Engineers Comments Regarding Surface Water Drainage

Application Reference:	BN/53/26/DOC	Reviewer Reference:	ADC/EXT2/D2134/107
Planning Officer:	Simon Davis	Date of Review:	29.04.2026
Site Name:	Land at Angels Nursery Yapton Road Barnham PO22 0AY		
Application Description:	Approval of details reserved by condition following the grant of BN/84/20/PL relating to conditions 3-as built drawings and 5-updated copy of management manual		
Assessment Number:	1

Application Reference: BN/53/26/DOC Site Name: Land at Angels Nursery Yapton Road Barnham PO22 0AY	Initial Issue Date: 29.06.2026 Issue Date: 29.06.2026 Reviewer Reference: ADC/EXT2/107
---	--

Windmill View, Barnham - ENHANCED Proposals - Sheet 2

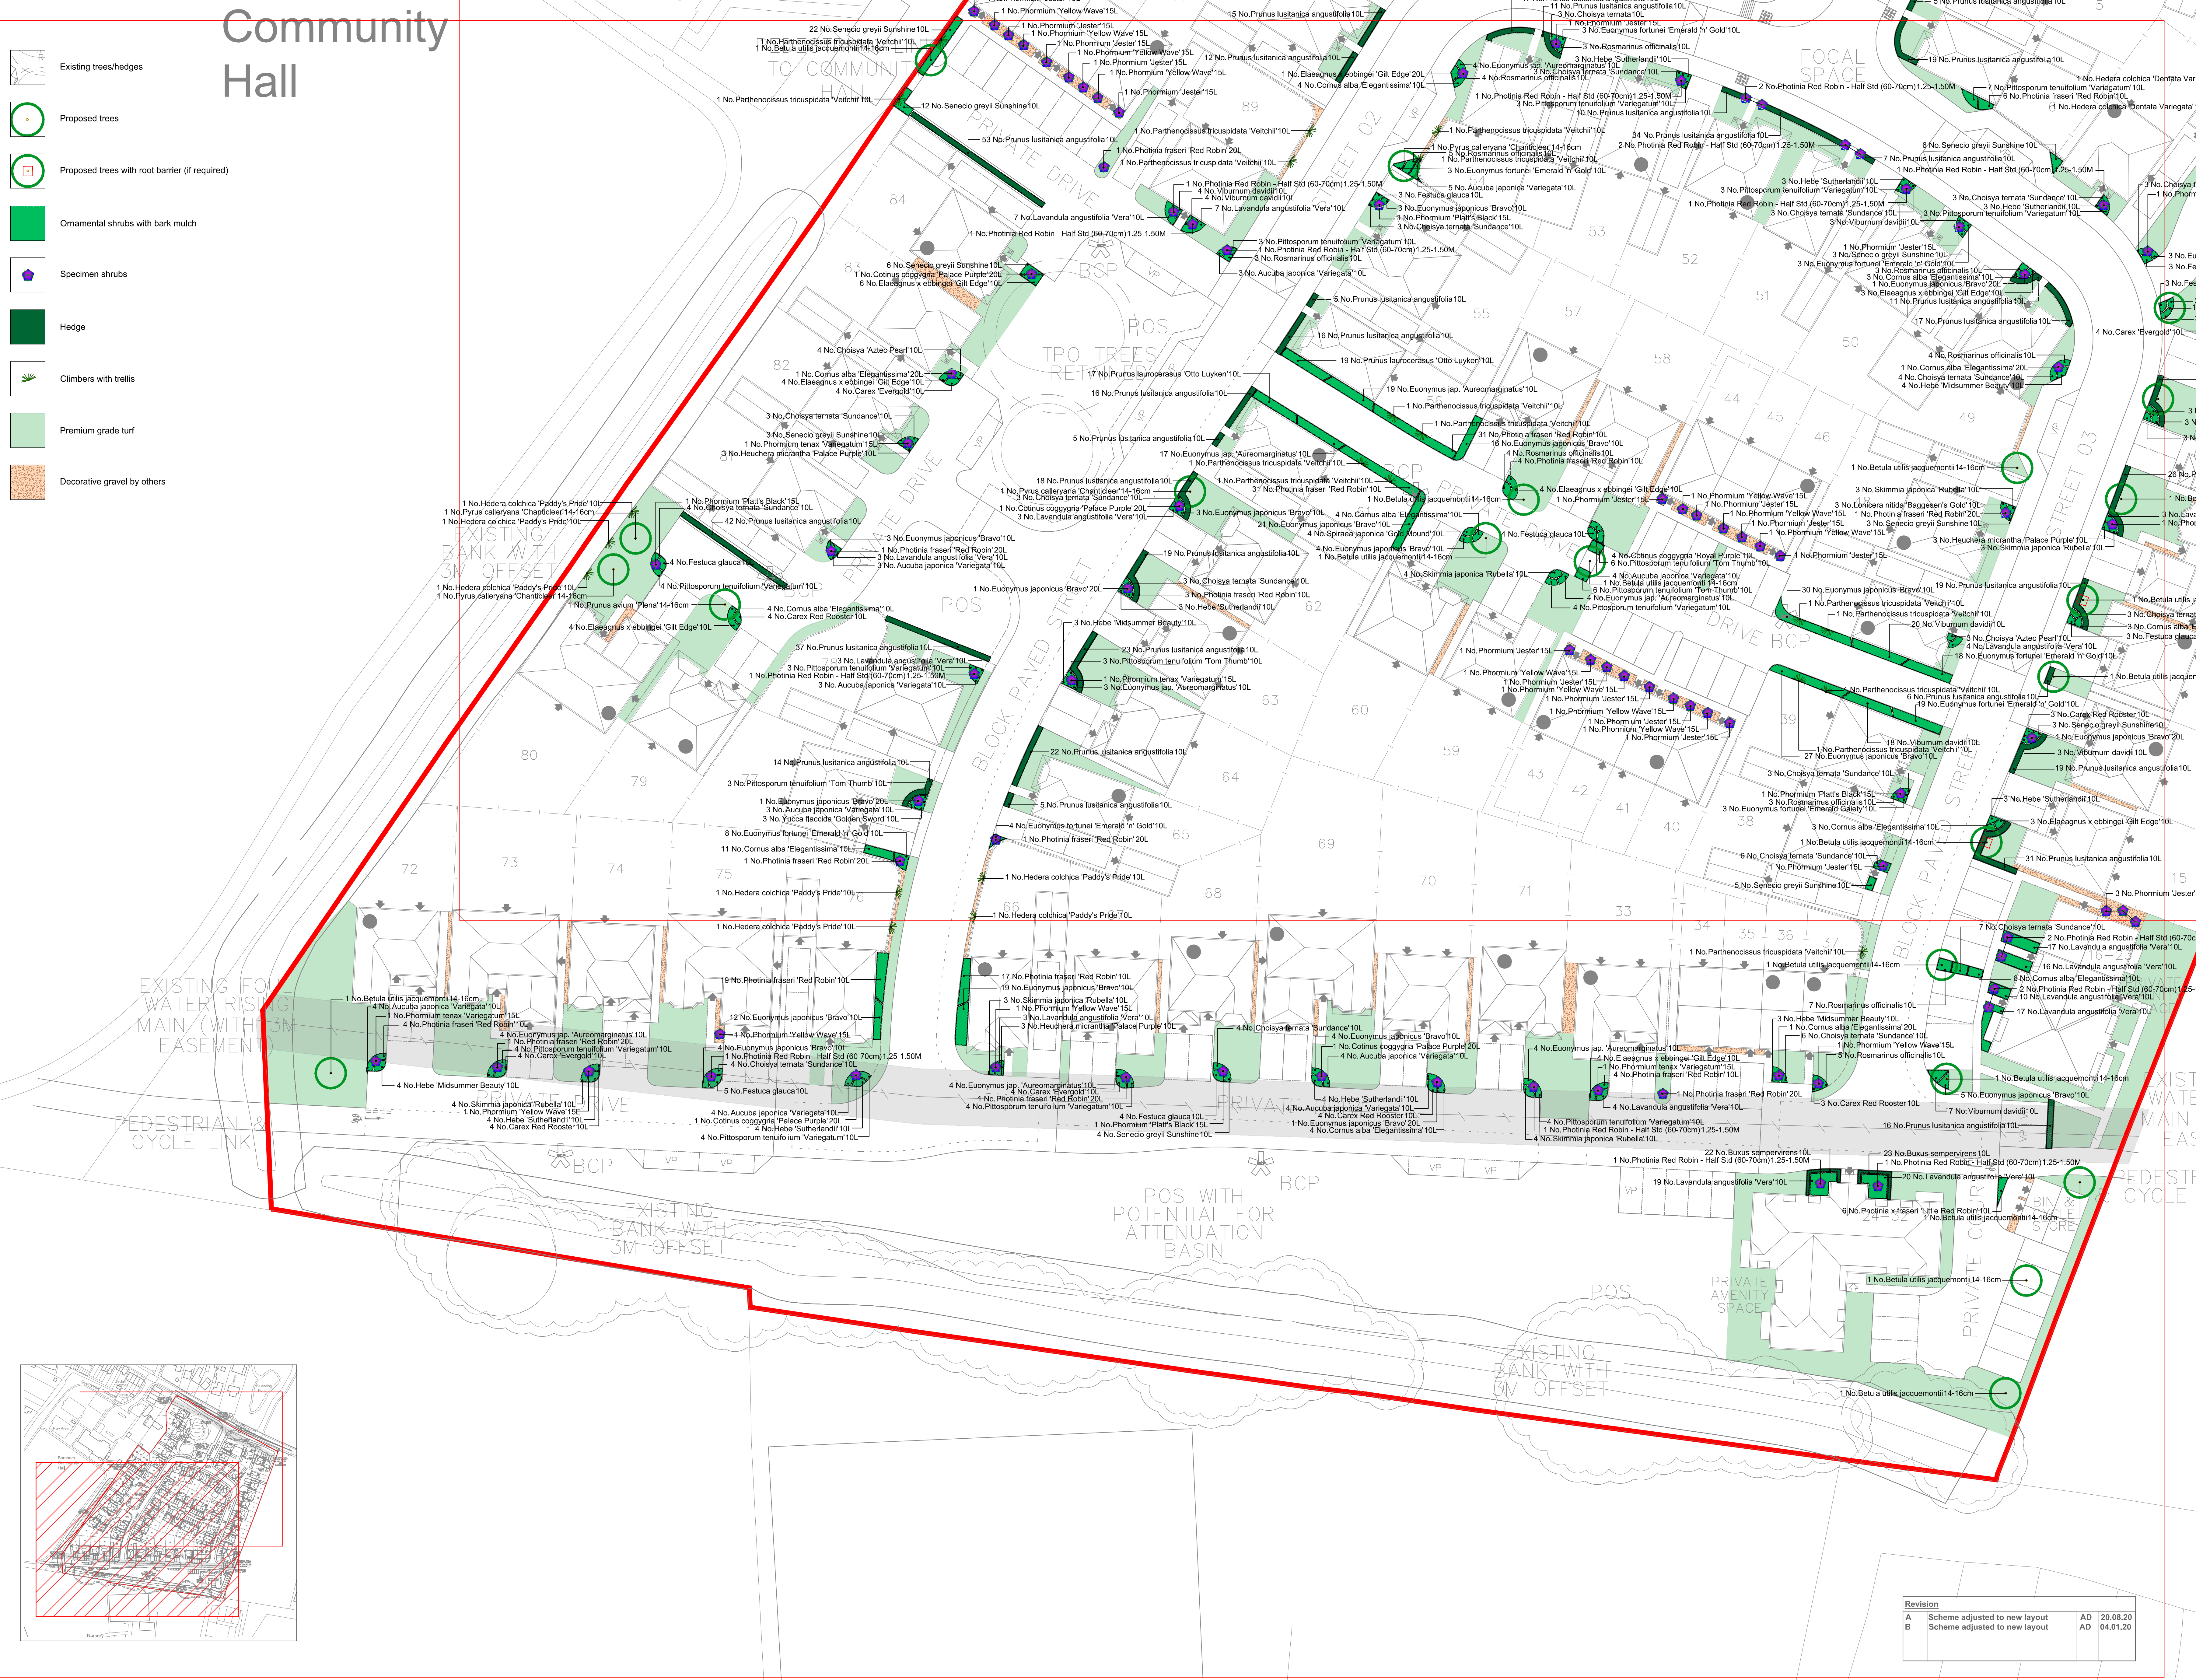
ADC Response
(BN/152/24/DOC)
15/01/2025
Landscaping drawing P19-2044_02 has been supplied as before. In addition another landscaping drawing for 'enhanced proposals' (Covey Design) has been supplied reference 17890 02 Rev B.

Both drawings however are based on a different site layouts compared to the SUDS/engineering plans that we understand have been implemented.

that have/will be installed to the final site layout. Designer Response (BN/152/24/DOC) 04/02/2025 The approved landscaping plans are clearly defined in section 2.1.4 within the report are presented in appendix A for reference. These are the drawings that are documented in associated planning decision notice/ approval. ADC Response (BN/152/24/DOC) 23/04/2025 To clarify the earlier comment, it would appear that both drawings however appear to show different planting proposals so there is some uncertainty of planting to be reviewed in vicinity of the drainage and SUDS features. Please provide the landscaping proposals that have/will be installed to the final site layout.				
--	--	--	--	--	--

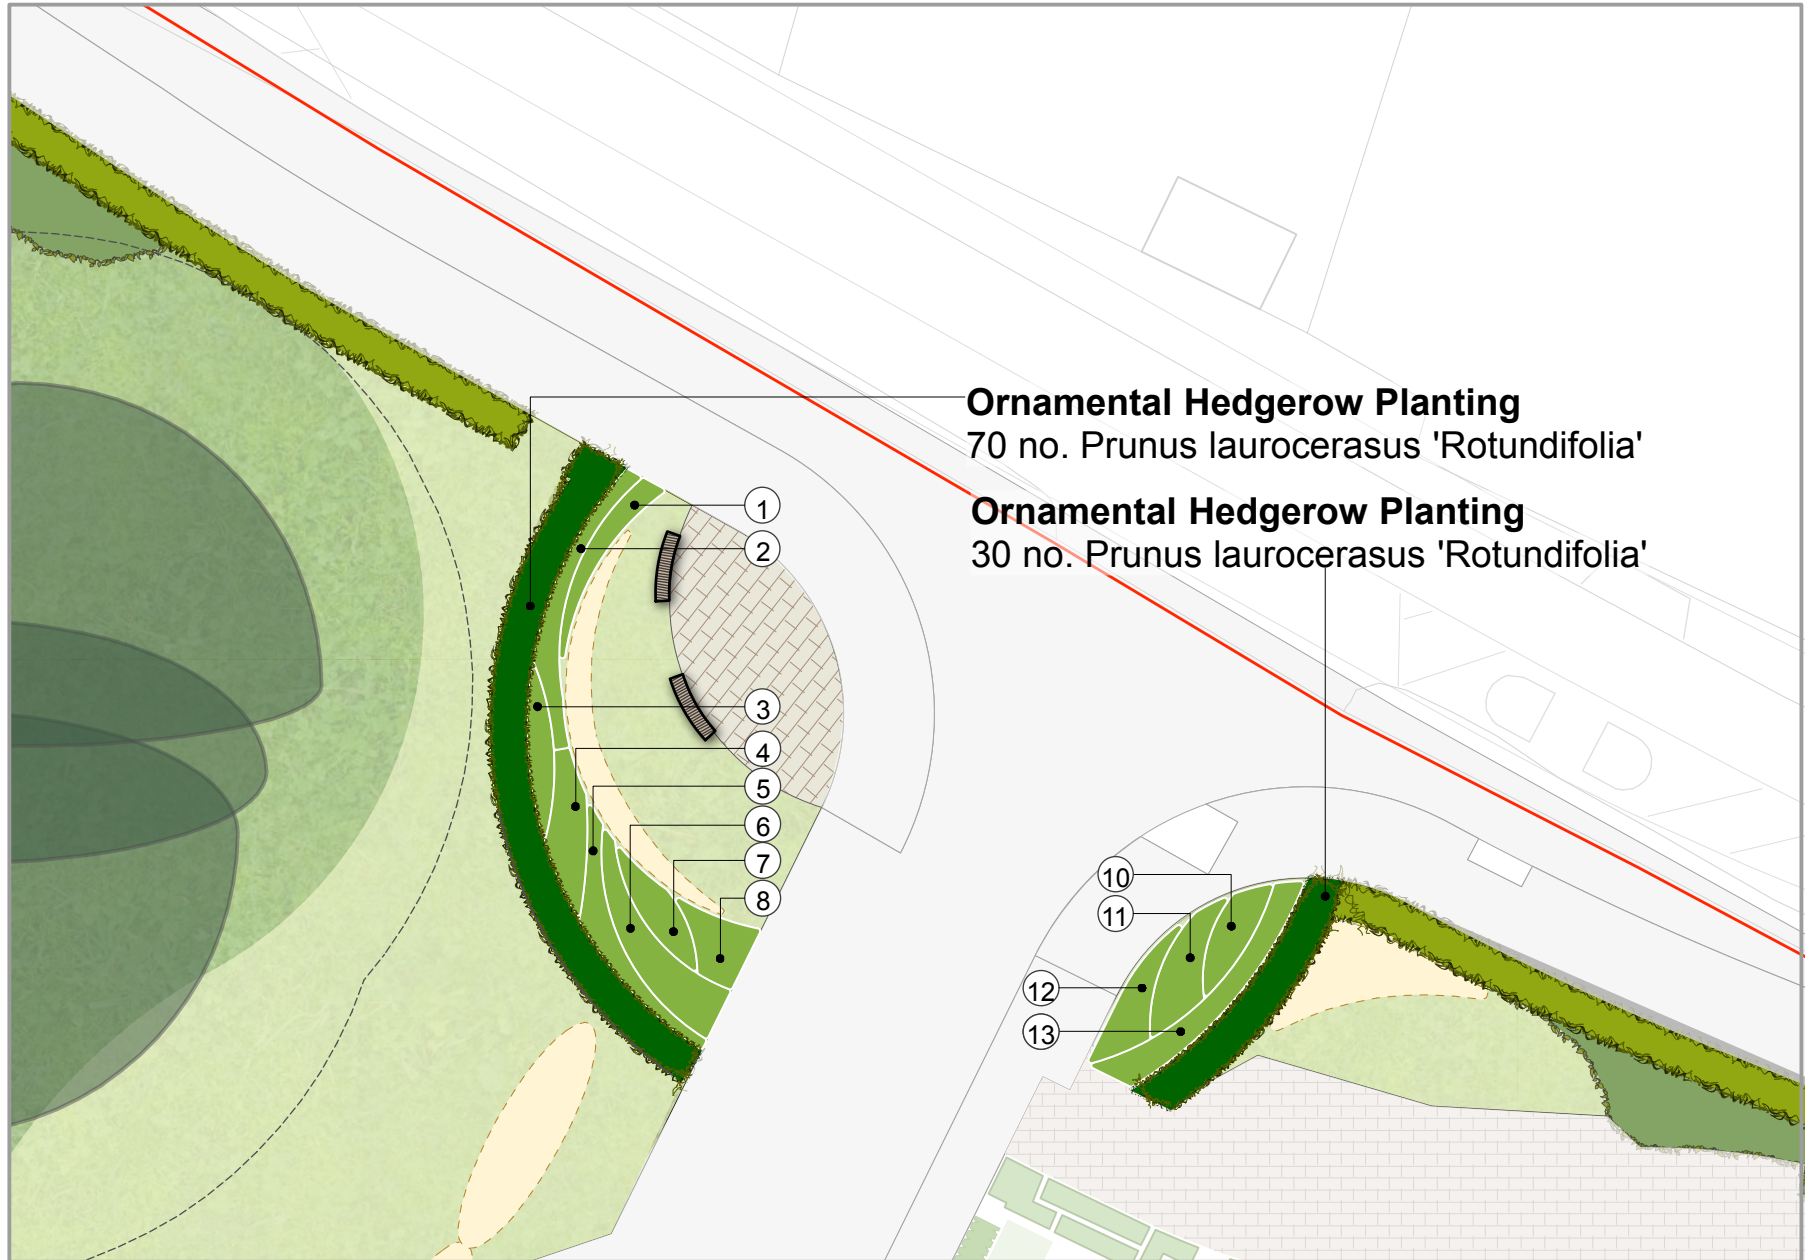
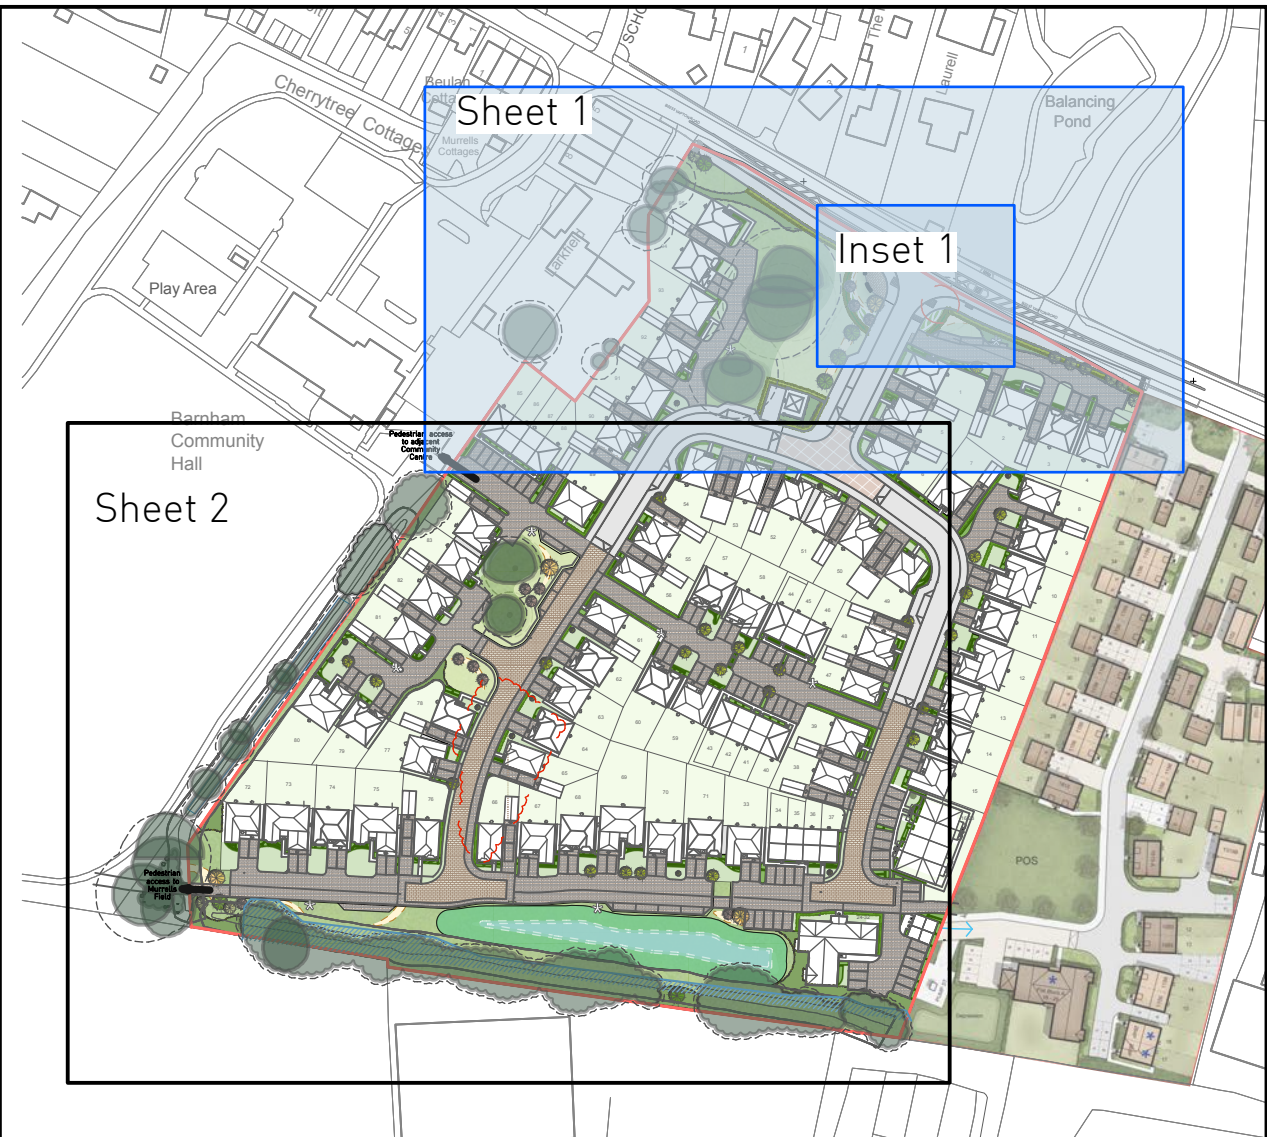
ADC Response
[BN/58/24/DOC]
10/09/2024:
The landscaping drawing (P19-2044_02) for the public open space appears to be based on a different site layout. Please provide the correct landscaping drawing.

Please provide the landscaping proposals

appears to be conflicting with one of the landscaping proposals for the access to plot 81? Has landscaping been installed as per these drawings?
